**KIRKLEES METROPOLITAN COUNCIL
INVESTMENT & REGENERATION SERVICE**

**DELEGATED DECISION TO DETERMINE APPLICATIONS FOR
NON-MATERIAL AMENDMENTS**

Reference No: **2022/NM/94050/W**

Description: Non material amendment to previous permission
2020/90725 for erection of 68 dwellings with
associated access, parking and open space (revised
plans)

2 Bed 3 Person
70.0 sq.m / 753 sq.ft

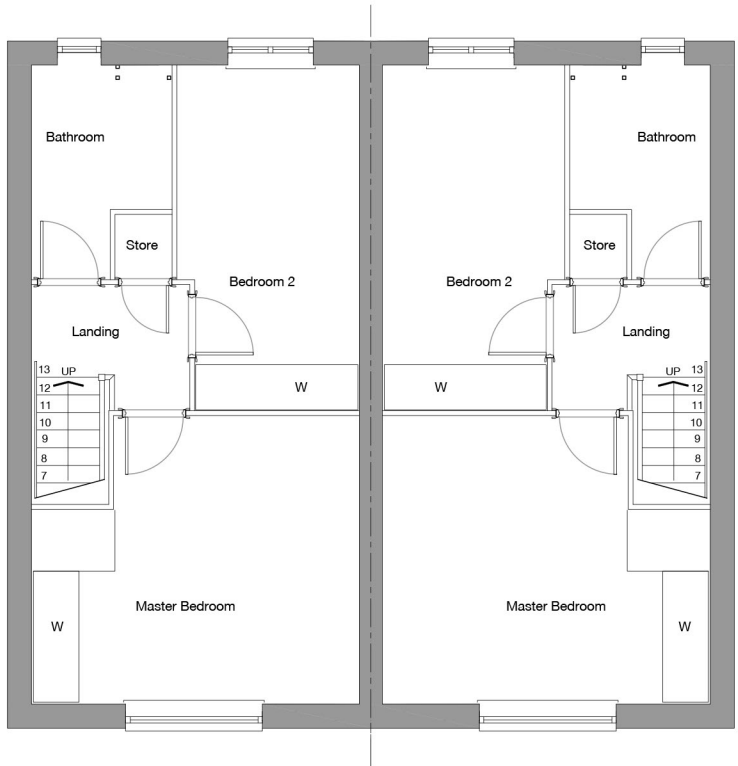
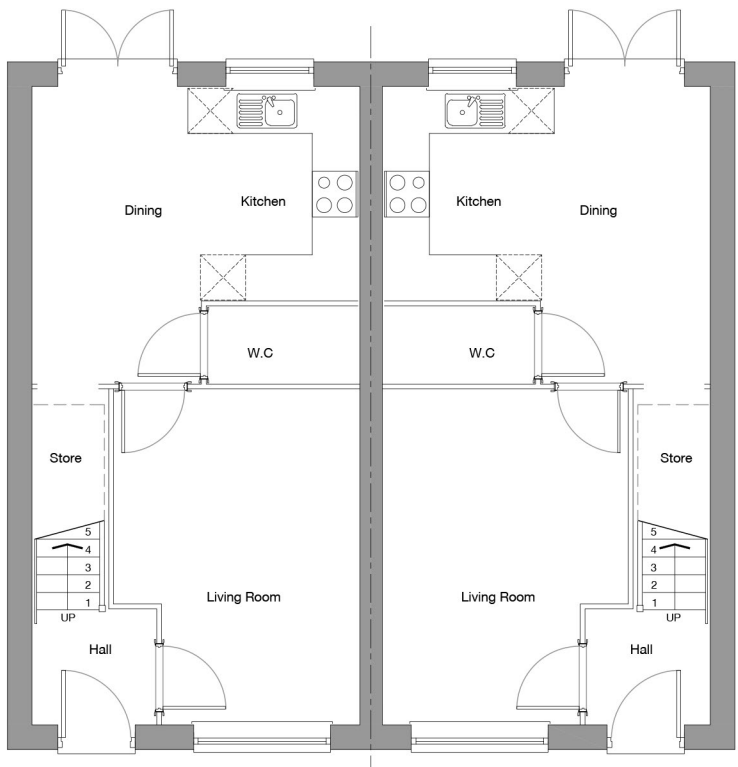
On the matter of size, the change to the 2bed property represents a 1.7% / 2.8% increase, while the 3bed would be a 5.1% decrease. These are accepted as minor alterations, which would not cause either respective unit to fall below their respective Nationally Described Space Standards nor affect their respective design or amenity in any material way.

Elevation Style - STONE & RENDER

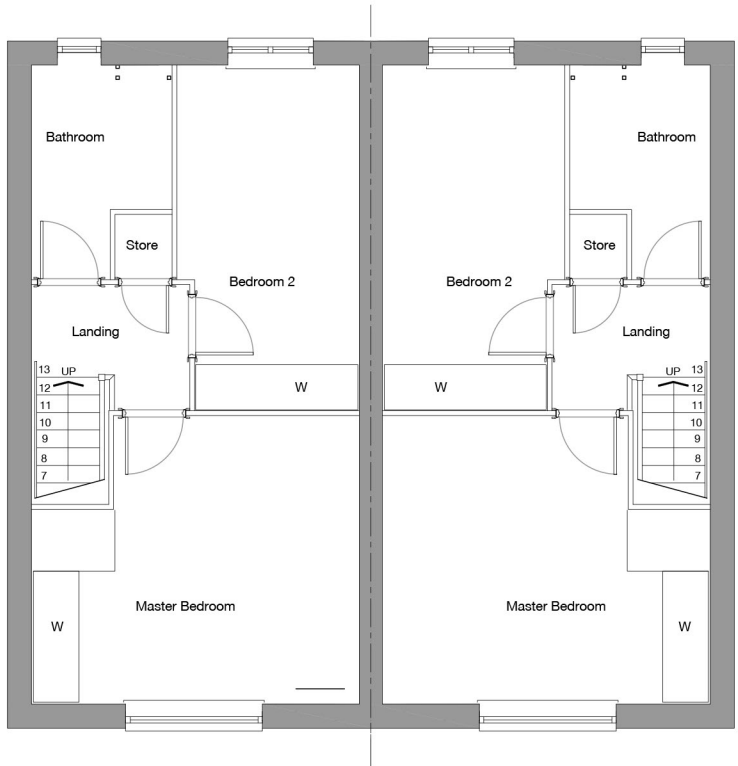
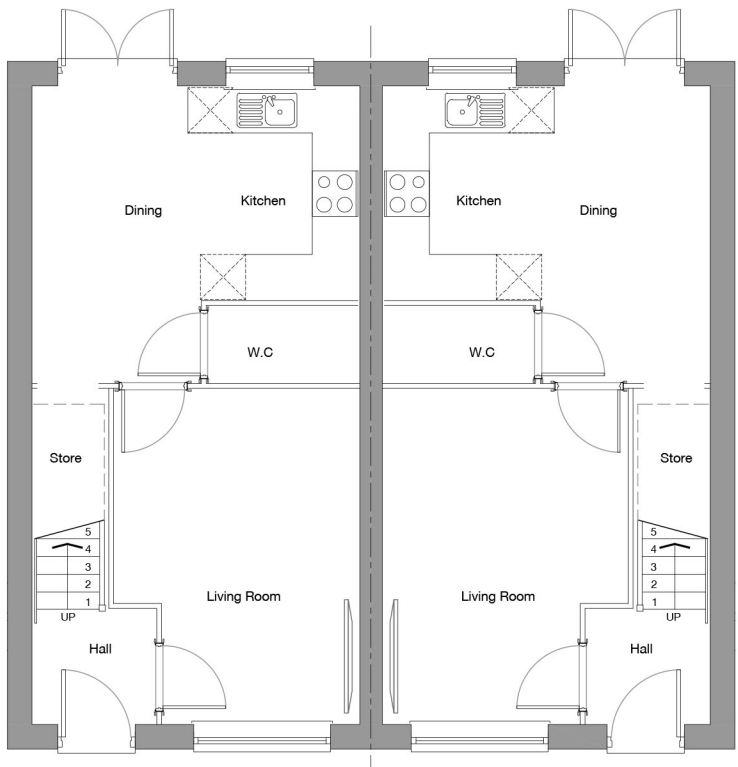
The amended proposal would notably include three plots having render on their front elevations. Notably however, the rear elevations facing onto Penistone Road would be retained as stone. The proposed render would remain a subservient material across the site, and would therefore be consistent with
